Your Ref :
Our Ref : BR/239/17/NMA

Section 96A of the Town & Country Planning Act 1990 (as amended)
Town and Country Planning (Development Management Procedure) (England) Order 2015 (as amended) - Article 10
Application for a non- material amendment following the grant of BR/135/13/ for moving rear garden entrance of Plot 7 to back of carport & hipped roof to carports.
Land to the rear of 6, Ockley Road, Bognor Regis,

Notes:		
KEY Previously Approved		
CLIENT	Willowcroft Homes	DATE
		06.10.16
PROJECT	Land to Rear of No 6, Ockley Rd, Bognor Regis, PO21 2HW	JOB NO.
		1516132
DRAWING TITLE	Units 4 & 5 Floor & Roof Plans	DRAWING NO.
		27
THIS DRAWING IS COPYRIGHT © Western Design Ltd 2016		REVISION
		B
PLANNING

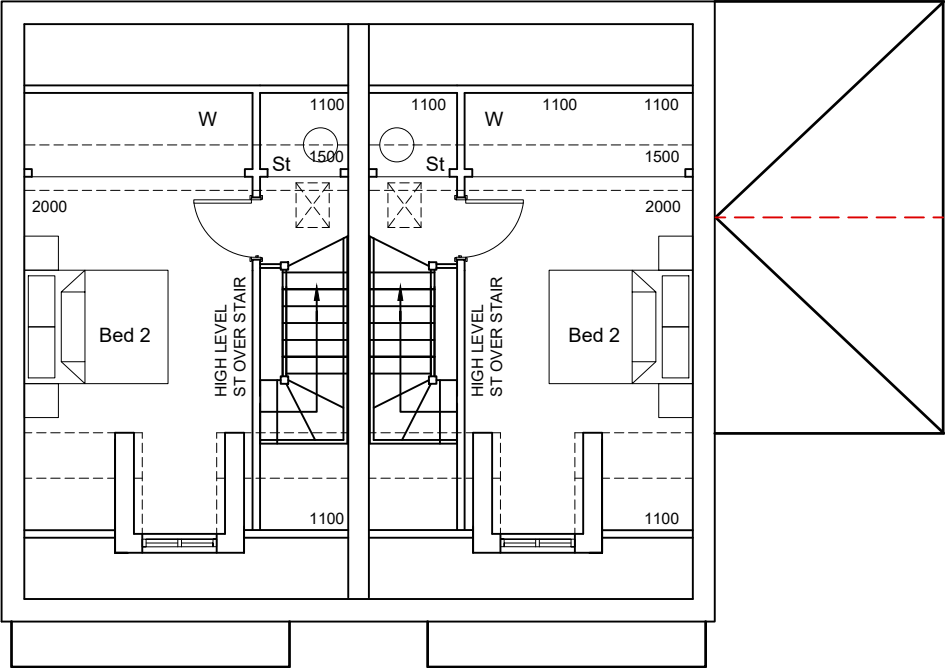
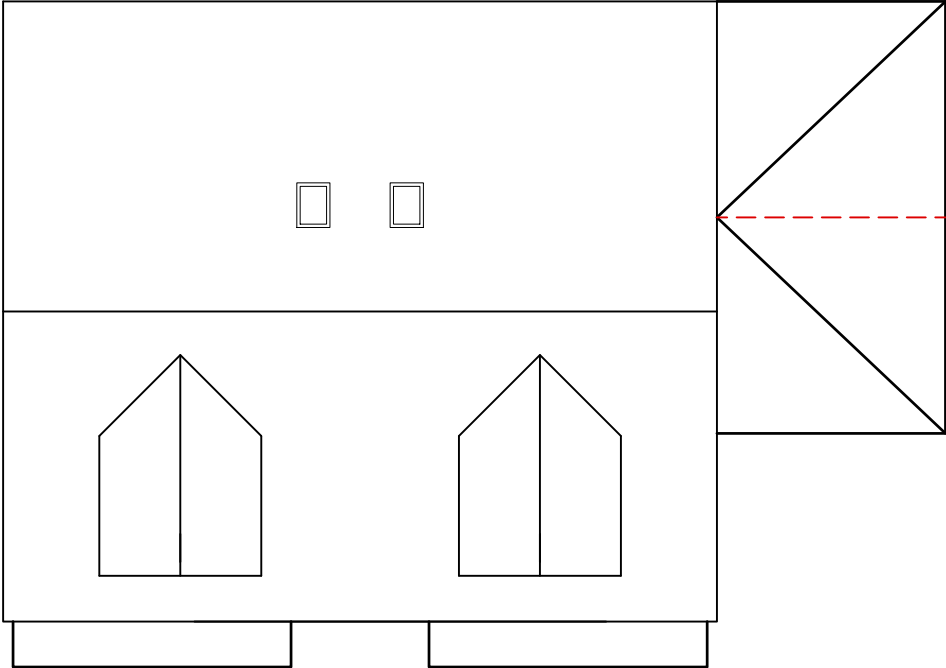
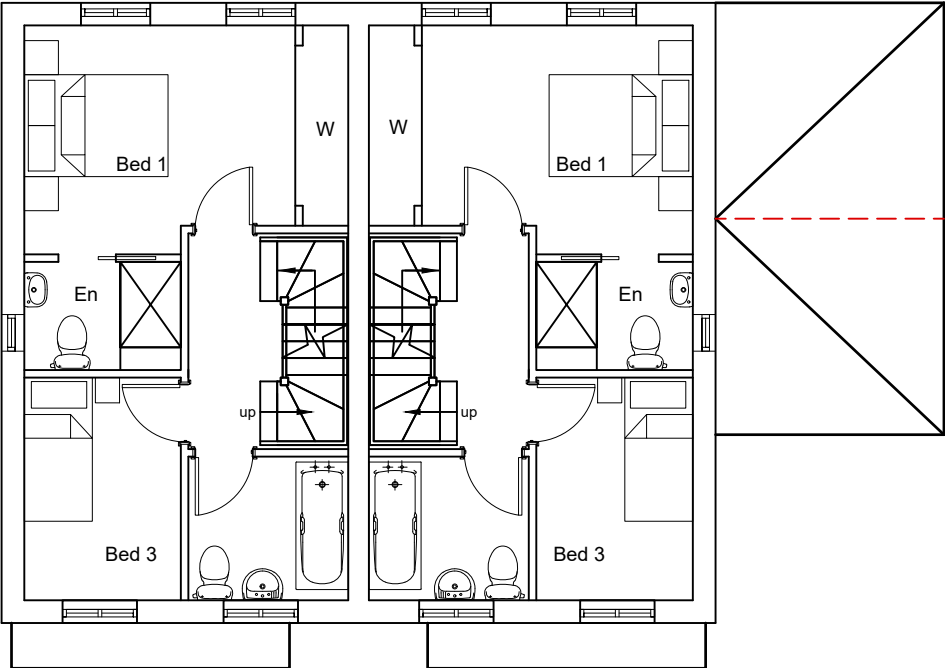
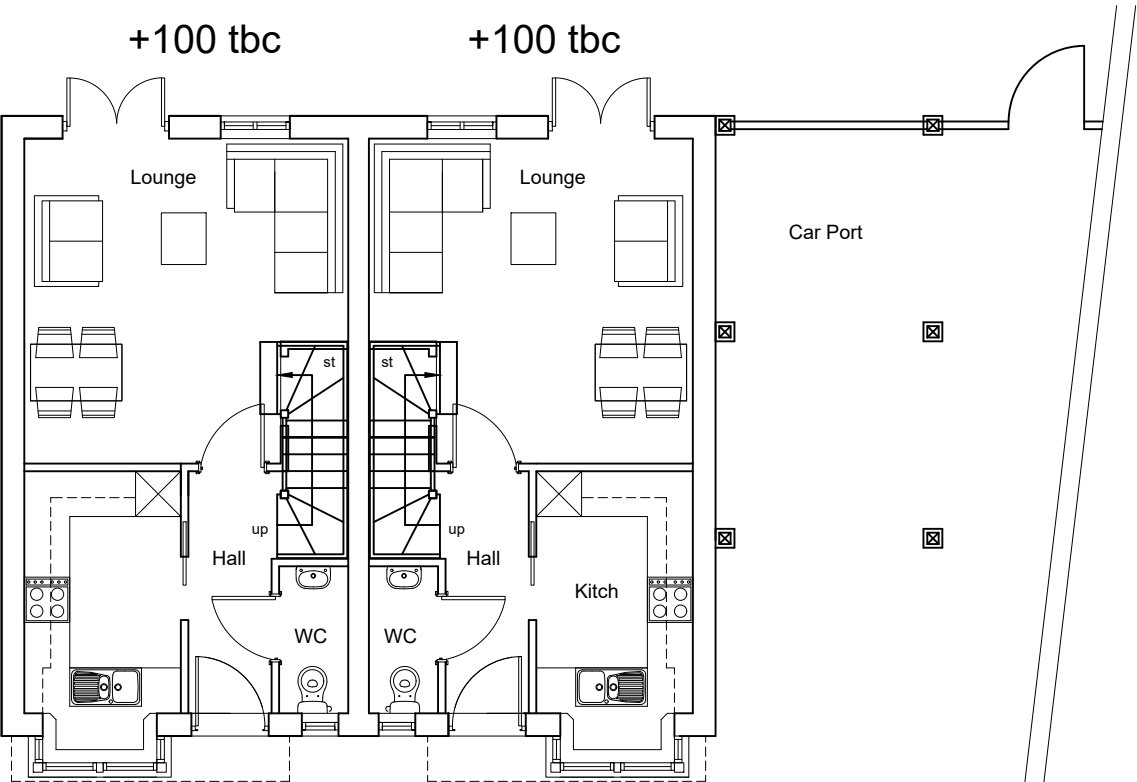
- * Alter the roofs of both car ports (plots 5 & 7) from gable to fully hipped; and
- * Extending the garden of Plot 6 by moving the rear entrance of plot 7 to the North side of the car port for plot 7.

Drawing 02 Rev H "Proposed Site & Landscape Plan" (08/09/17);
Drawing 27 Rev B "Units 4 & 5 Floor & Roof Plans";
Drawing 28 Rev B "Units 4 & 5 Elevations";
Drawing 23 Rev B "Units 6 & 7 Floor Plans"; and
Drawing 24 Rev B "Units 6 & 7 Elevations".
